Longfield Solar Farm

Applicant Comments on Submissions Received - Deadlines 1A and 1B

Document Reference: EN010118/EX/8.8

September 2022

Figure 2-12

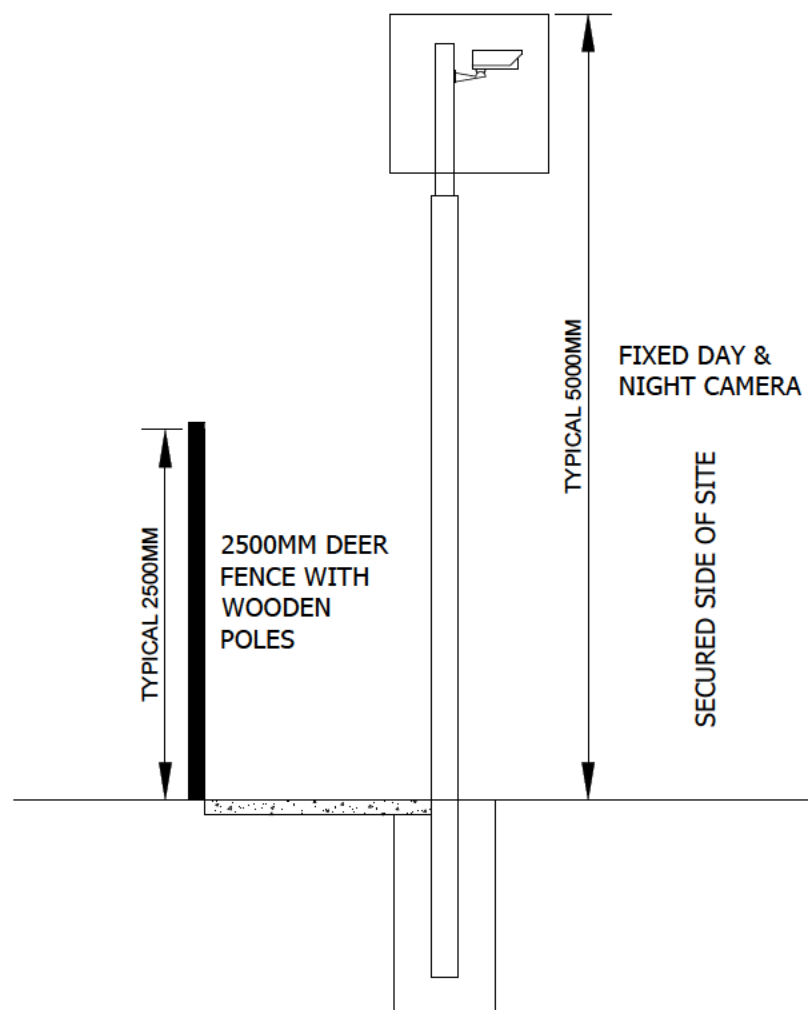
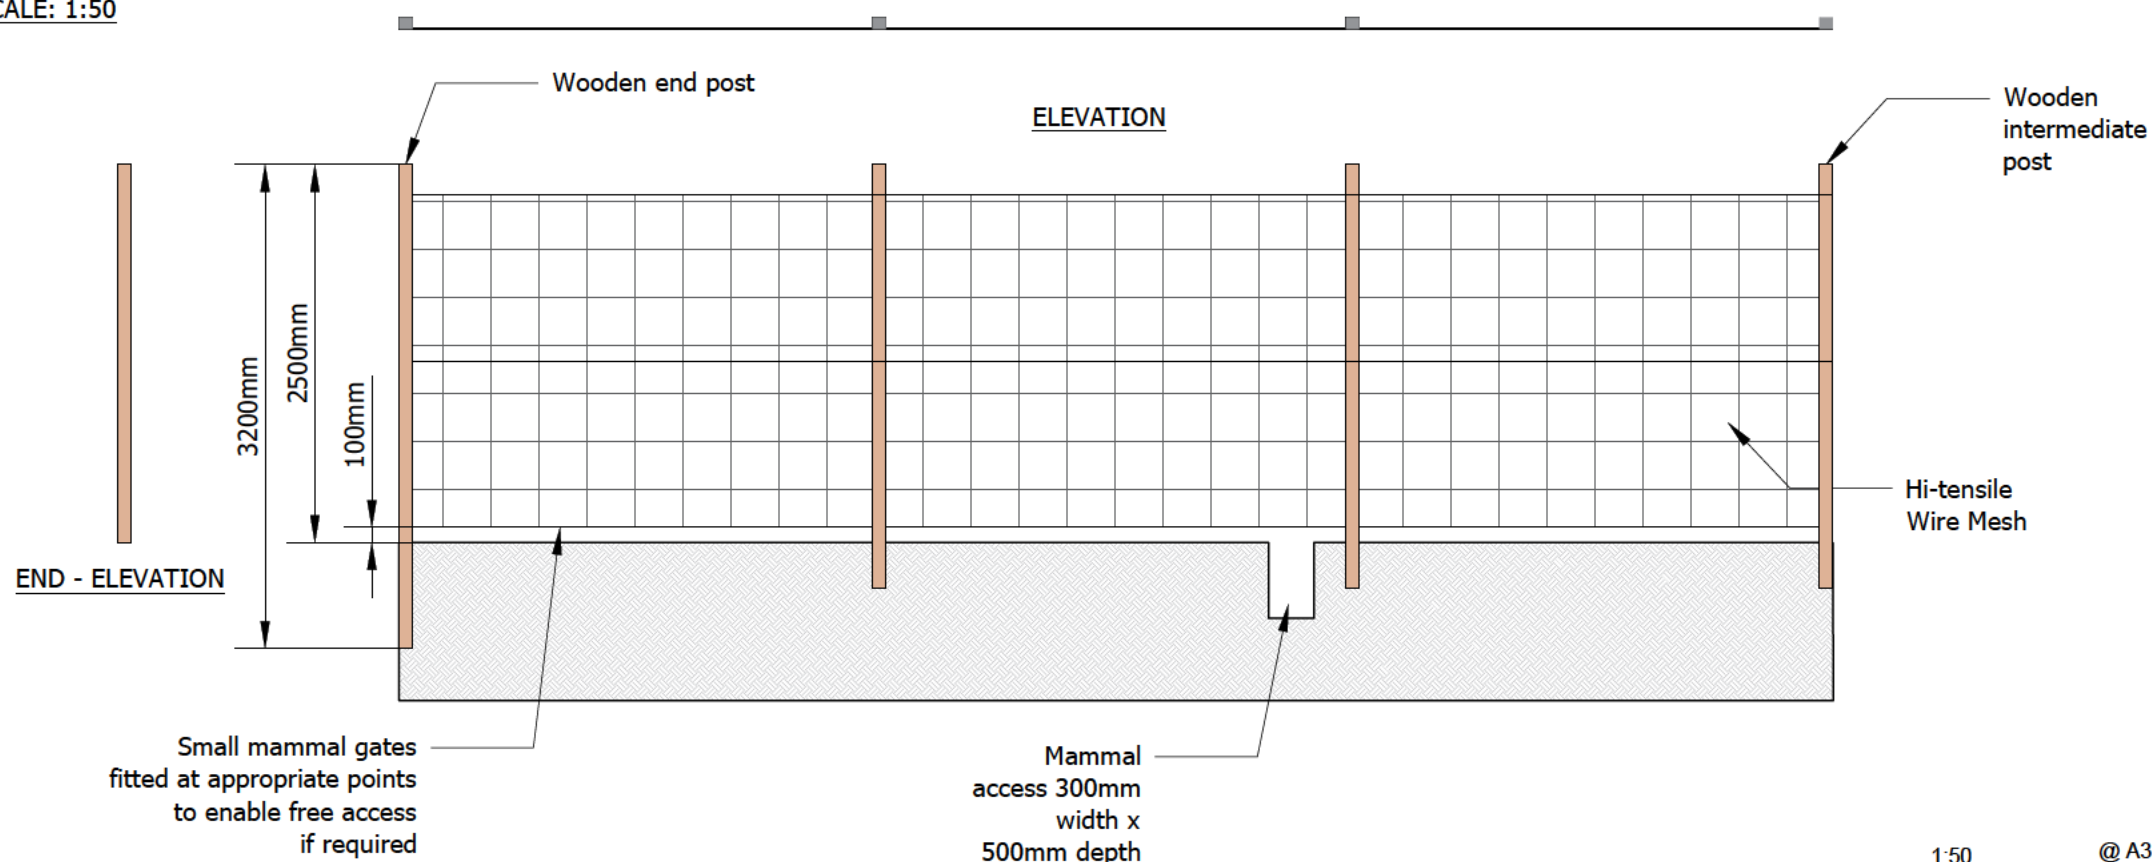
BDC 7.101	<p>Deer fencing</p> <p>BDC have reviewed Figure 2-12 (Deer Fencing/CCTV) [EN010118/APP/6.3] and have the following comments to ensure the successful establishment of the fencing, based on published guidance:</p> <p>The fencing will be installed at appropriate height and will avoid Muntjac entering the site. However, the specifications may need to be 2.6-2.8 m in height to fully rule out large deer (i.e. Fallow Deer) from jumping over the fence.</p> <p>The wire mesh will need to prevent animals from passing through the openings. Therefore, mesh size at the base of fences should be no more than 75 x 75mm due to the presence of muntjac across the wider landscape.</p>	<p>This is still being considered by the Applicant and a final position is reflected in the Statement of Common Ground between the Applicant and the Host Authorities [EN010118/EX/8.4(A)].</p>

LIR Ref.	Summary	Applicant Response
	<p>Wires should have a diameter of at least 2.5 mm and should consist of a rust-free material.</p> <p>The mesh should be fixed such that deer cannot pass under the fence. This may involve burying the wire mesh 20-40cm underground, with contingencies to still allow Badger through if possible (i.e. badger gates’).</p> <p>No lighting should be installed as part of the CCTV, unless it includes infrared lighting.</p>	
<p>BDC 7.103</p>	<p>Finally, it is suggested that both of the below planning conditions would be appropriate: A) PRIORITY TO COMMENCEMENT: BIODIVERSITY MONITORING STRATEGY</p> <p>No development shall take place, including demolition, ground works and vegetation clearance, until a biodiversity monitoring strategy has been submitted to, and approved in writing by, the local planning authority. The purpose of the strategy shall be to monitor the habitat creation and the presence of Protected and priority species. The content of the Strategy shall include the following.</p> <p>a) Aims and objectives of monitoring to match the stated purpose.</p> <p>b) Identification of adequate baseline conditions prior to the start of development.</p> <p>c) Appropriate success criteria, thresholds, triggers and targets against which the effectiveness of the various conservation measures being monitored can be judged.</p> <p>d) Methods for data gathering and analysis.</p> <p>e) Location of monitoring.</p> <p>f) Timing and duration of monitoring.</p> <p>g) Responsible persons and lines of communication.</p> <p>h) Review, and where appropriate, publication of results and outcomes.</p> <p>A report describing the results of monitoring shall be submitted to the local planning authority at intervals identified in the strategy. The report shall also</p>	<p>The Applicant has some initial thoughts on the wording of the commitments as follows below. Notwithstanding, the detailed wording and securing mechanism will be discussed and agreed with the Host Authorities and a position reflected in the relevant SoCG and the certified documents, as appropriate, at a subsequent deadline.</p> <p>A) PRIORITY TO COMMENCEMENT: BIODIVERSITY MONITORING STRATEGY</p> <p>(1) No phase of the solar farm works or grid connection works may commence until a biodiversity monitoring strategy has been submitted to and approved in writing by the relevant planning authority for that phase or, where the phase falls within the administrative areas of both Braintree District Council and Chelmsford City Council, both relevant planning authorities.</p> <p>(2) For the purposes of sub-paragraph (1), “commence” shall include site clearance including vegetation removal.</p> <p>(3) The purpose of the strategy submitted under sub-paragraph (1) will be to monitor the habitat creation pursuant to the landscape and ecological management plan approved pursuant to paragraph 9 and the presence of protected and priority species within the Order limits. The strategy must include-</p> <p>a) Aims and objectives of such monitoring;</p> <p>b) Identification of agreed adequate baseline conditions prior to the start of development;</p> <p>c) Appropriate success criteria, thresholds, triggers and targets against which the effectiveness of the various biodiversity measures can be monitored and judged;</p>
